**Subject:** Rezoning Petition Review

**Date of Review:** April 28, 2022 (*Revised May 25, 2022*)

**Rezoning Petition #:** 21-258

**Location of Property:** Approximately 64.05 acres located along the north side of University City Blvd, east of Neal Rd, west side of I-85 and south of IBM Dr.

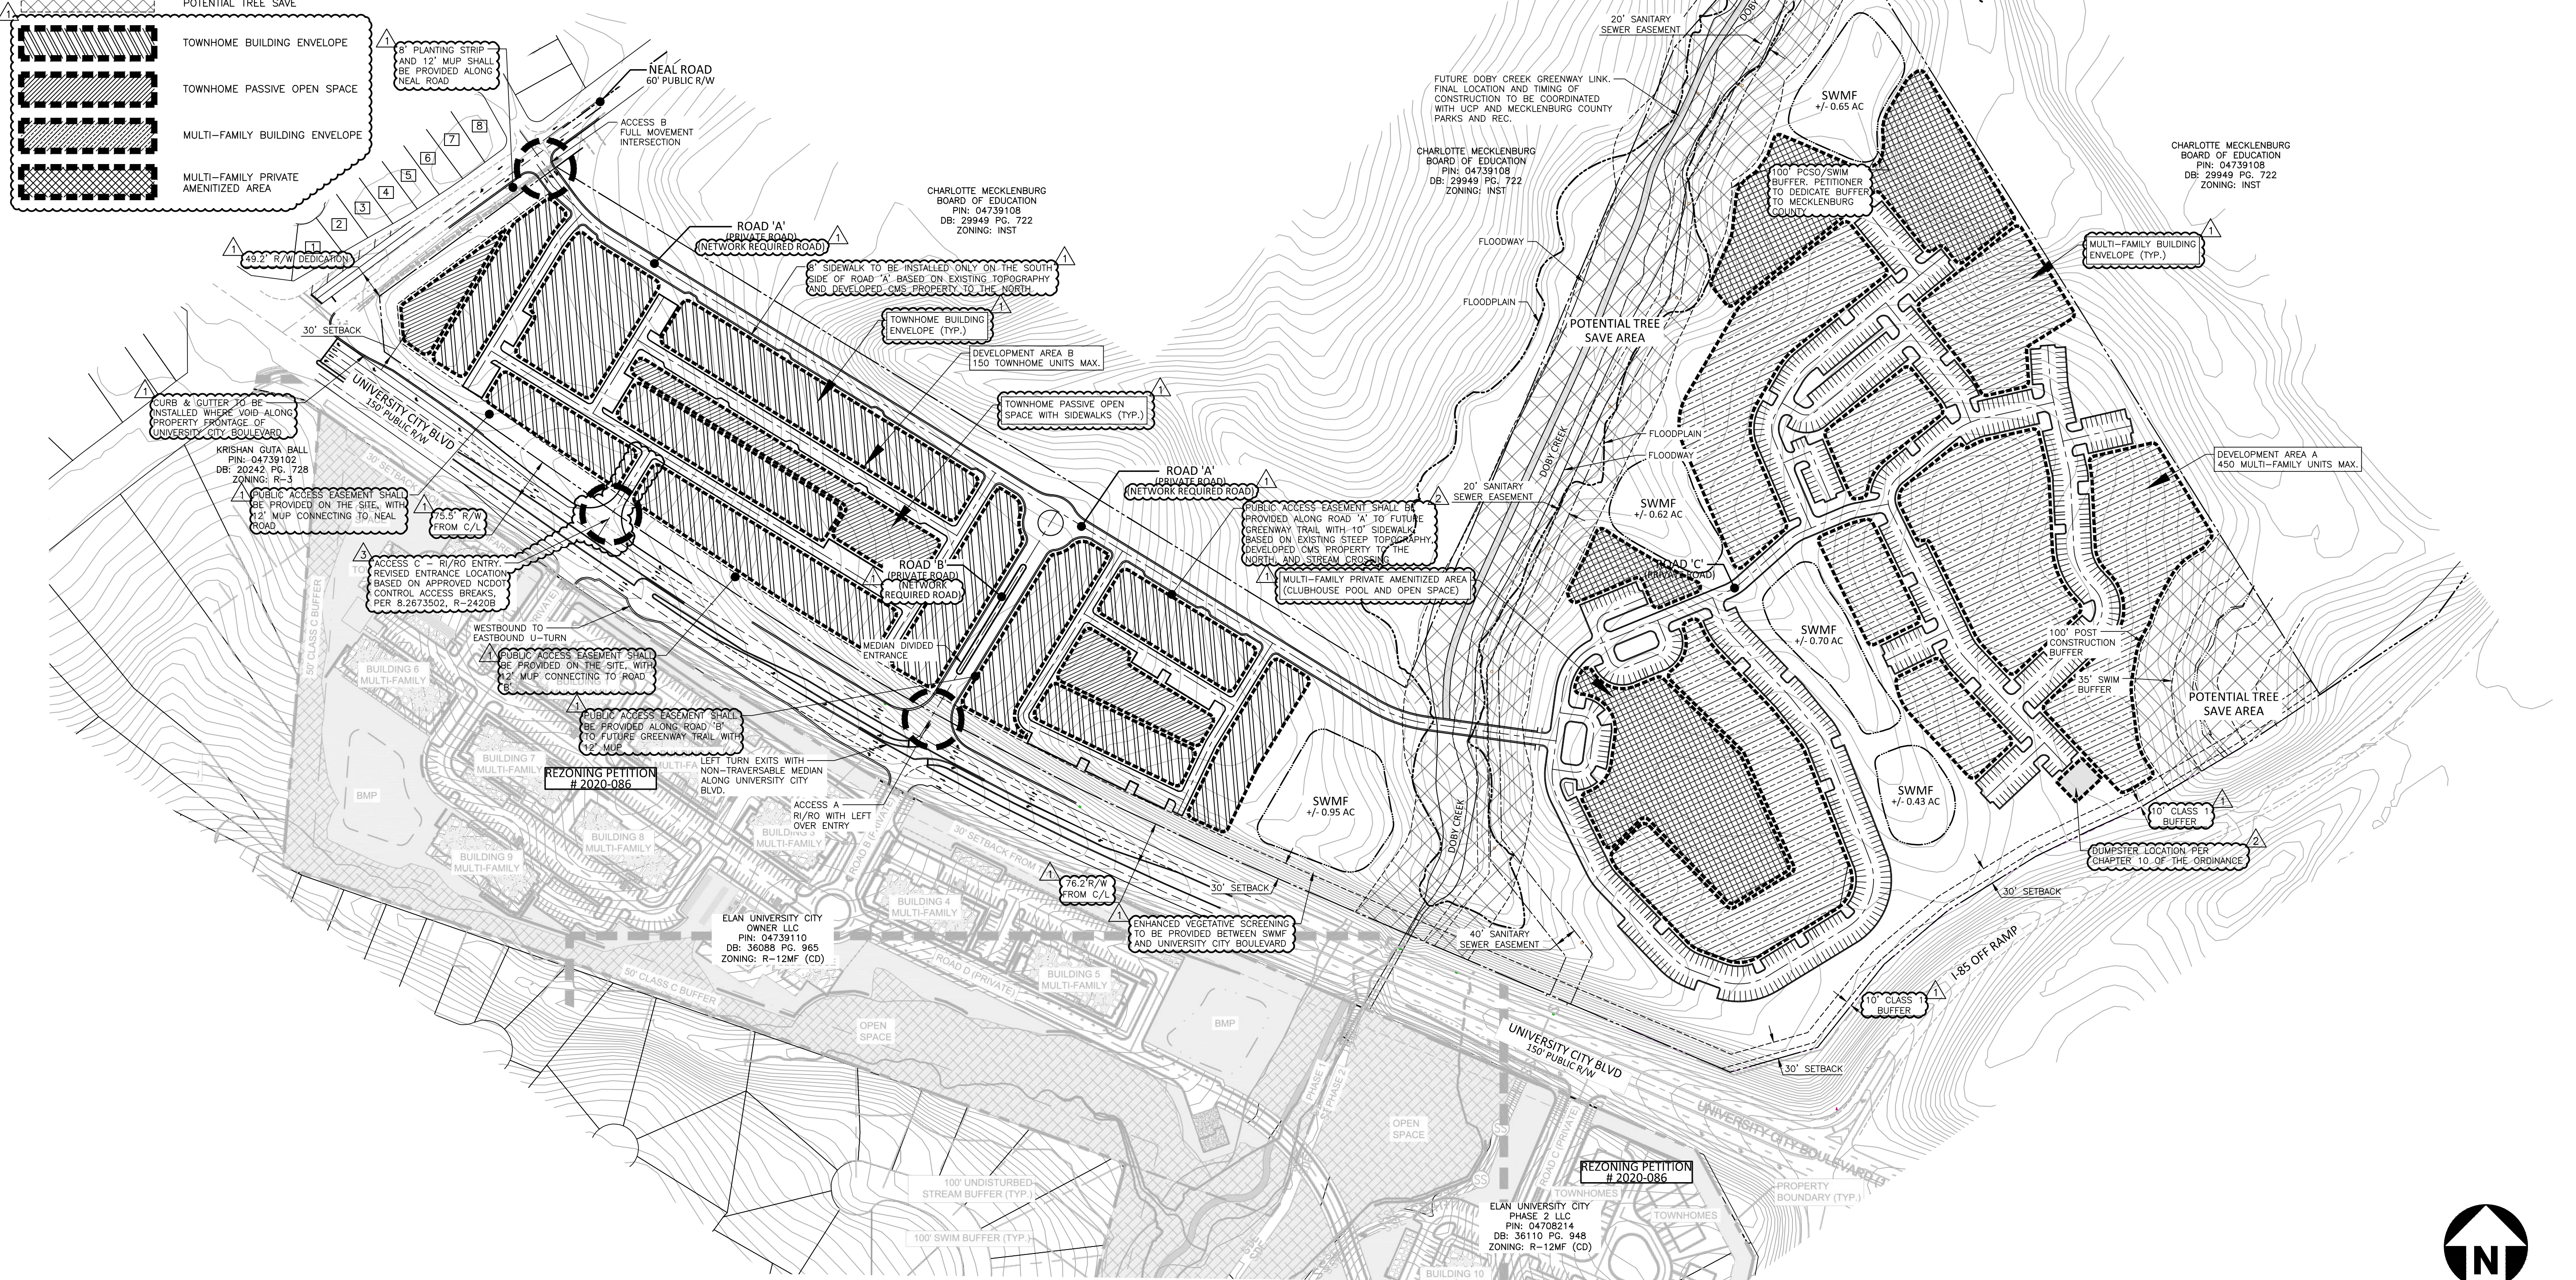
The proposed rezoning plan sheet indicates a proposed location for storm water management. Please include the following notes on the plan sheet under "Environmental Features": *The location, size, and type of storm water management systems depicted on the Rezoning Plan are subject to review and approval as part of the full development plan submittal and are not implicitly approved with this rezoning. Adjustments may be necessary in order to accommodate actual storm water treatment requirements and natural site discharge points.*
